Reference No:	2025/65/90113/E
Site Address:	Providence Place, Bradford Road, Cleckheaton, BD19 3PN
Description:	Listed Building Consent for internal and external alterations
Recommending Officer:	Edward Cheseldine

DECISION – GRANT LISTED BUILDING CONSENT

2025/90113 - Providence Place, Bradford Road, Cleckheaton, BD19 3PN

EXISTING FRONT ELEVATION @ 1:50
 WINDOW STYLE. A @ 1:50

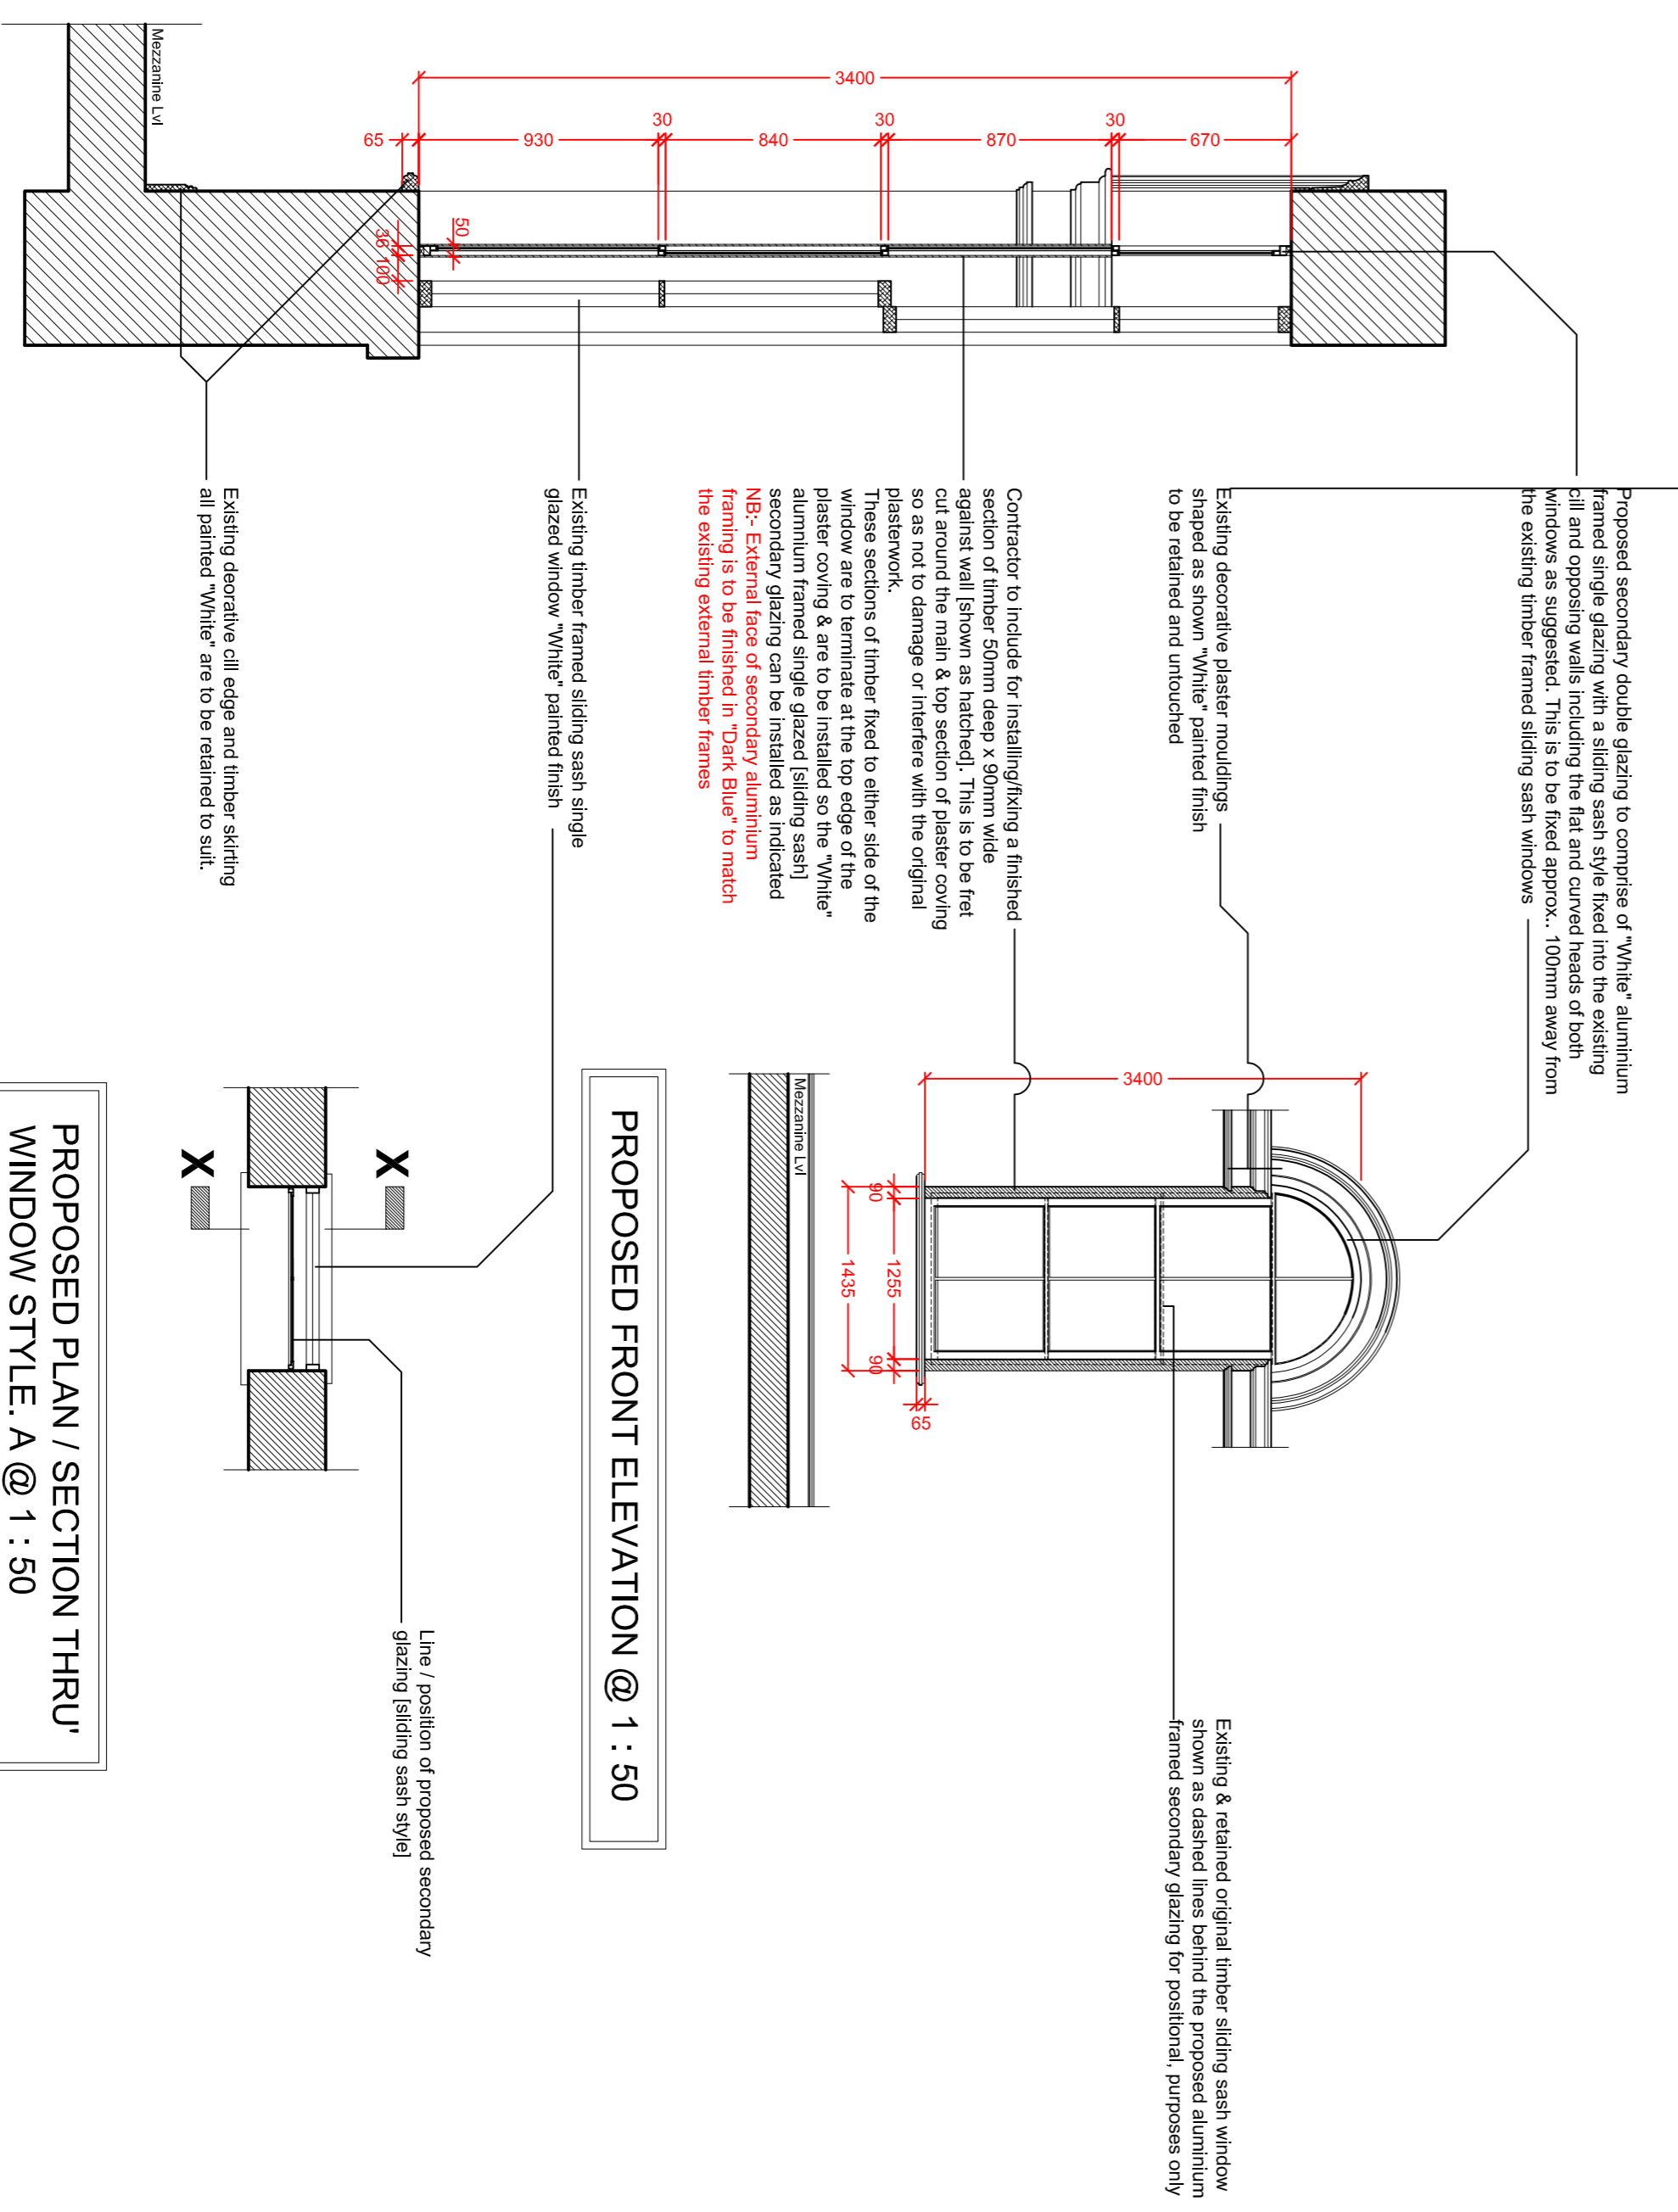
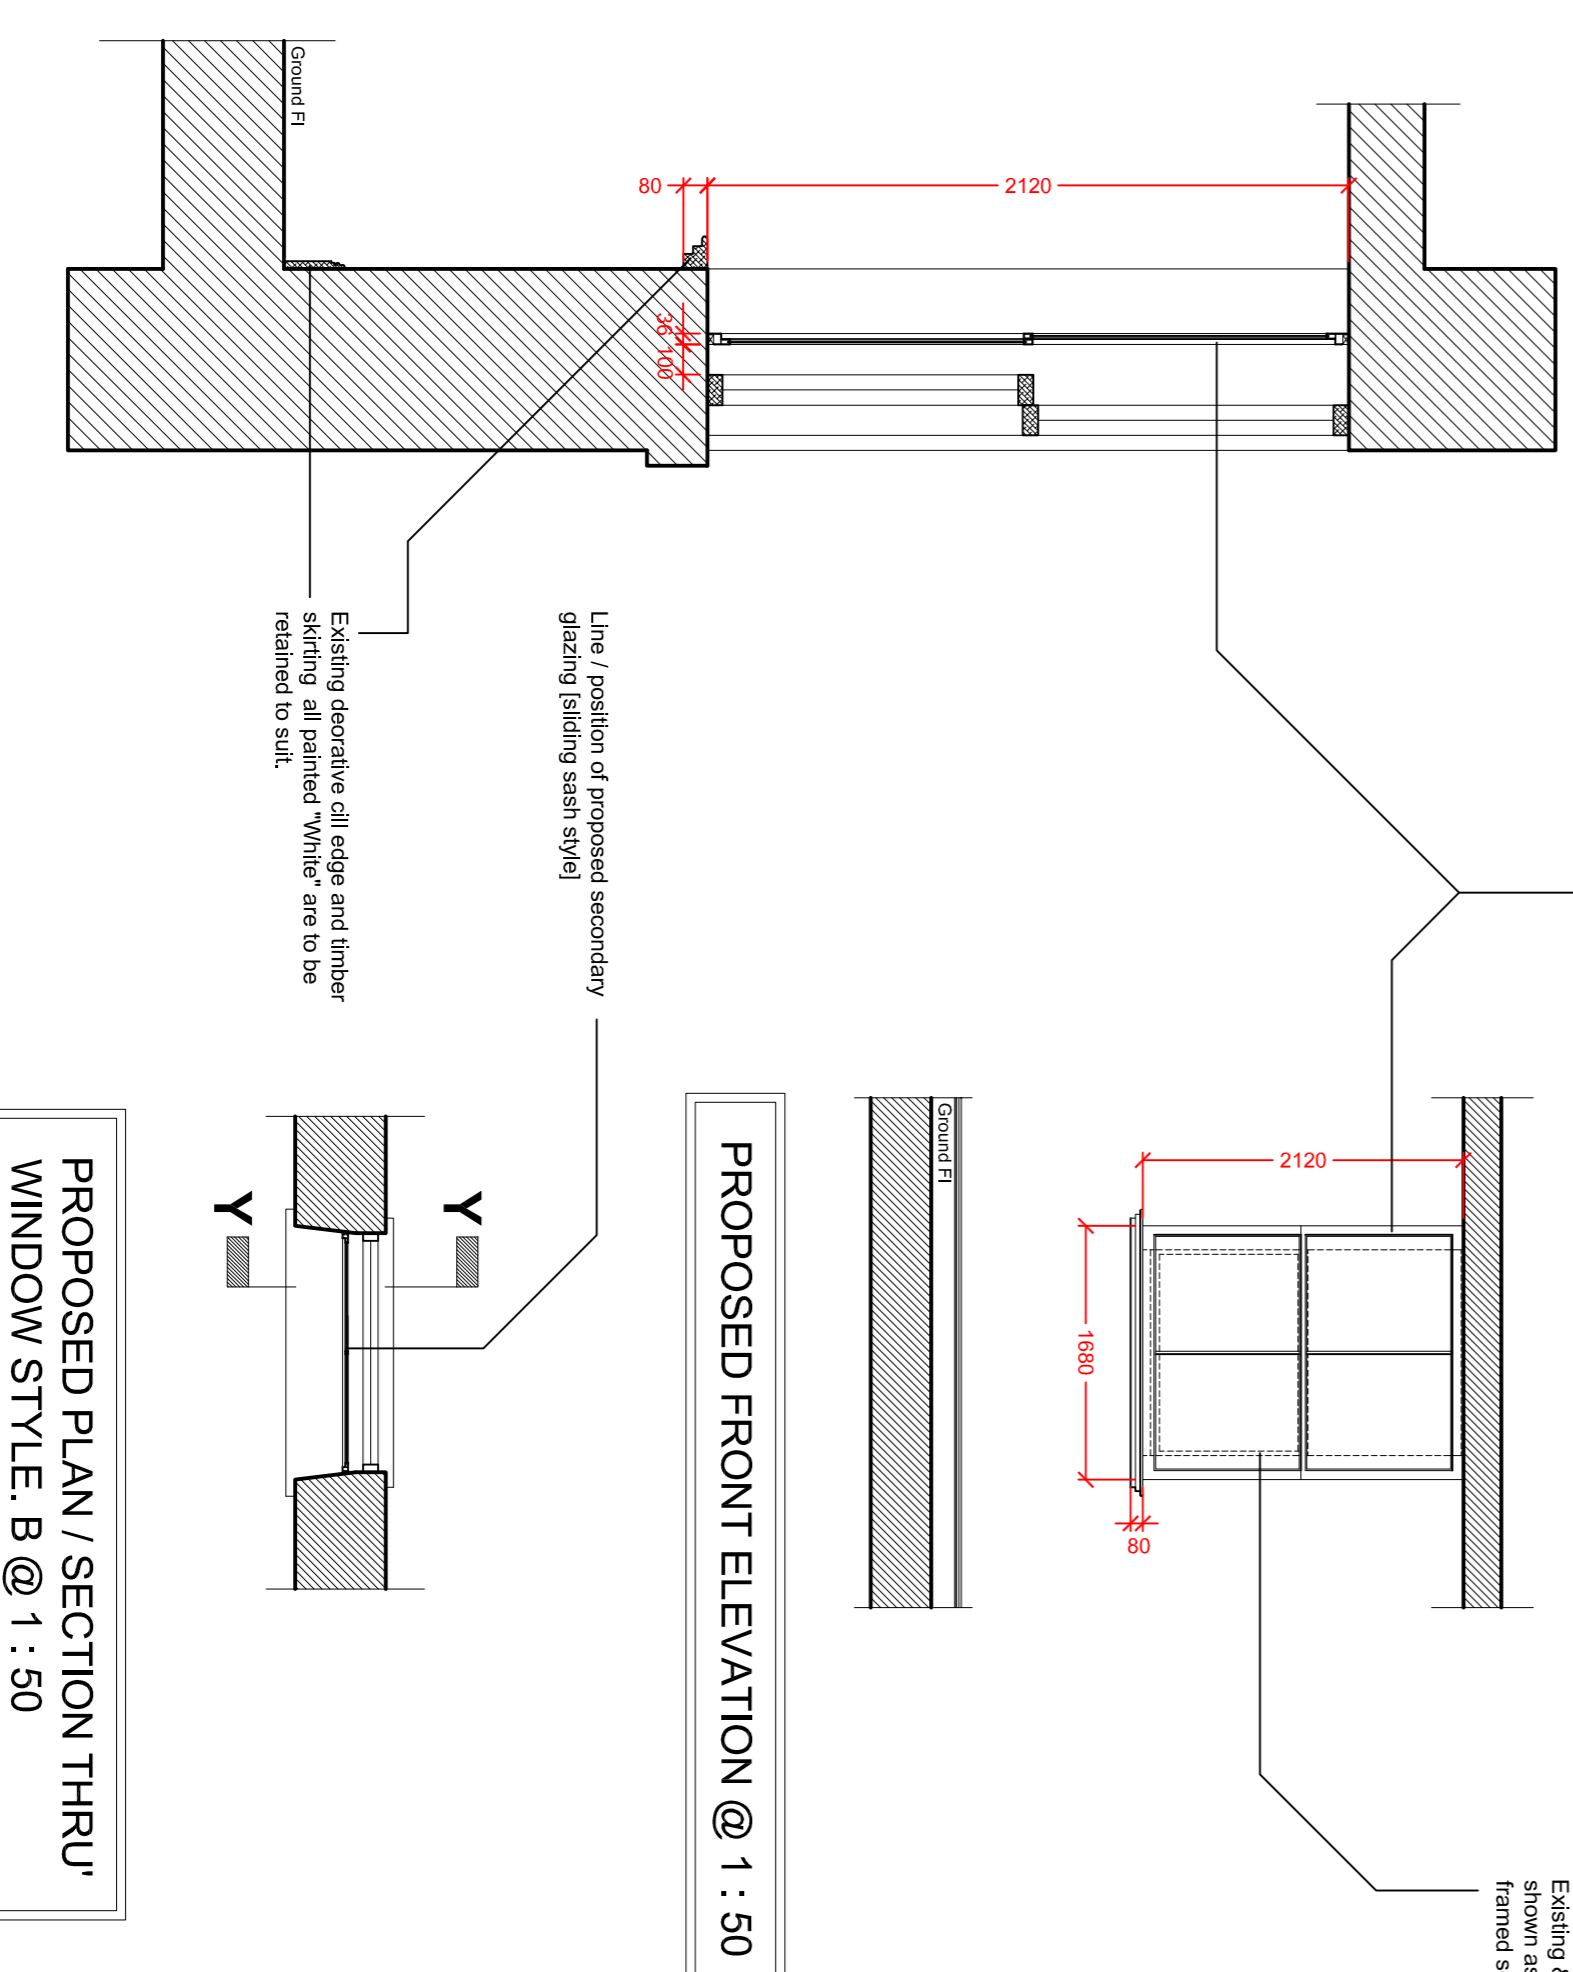
Secondary glazing is being installed to improve the thermal efficiency. Windows in place are original. The secondary glazing will have aluminium frames, single glazing in sliding sash style, set 100mm from existing sash windows. They will be fixed to fret cut timber sections to avoid removal of original plaster work. Glazing bars and colour scheme match with the original windows.
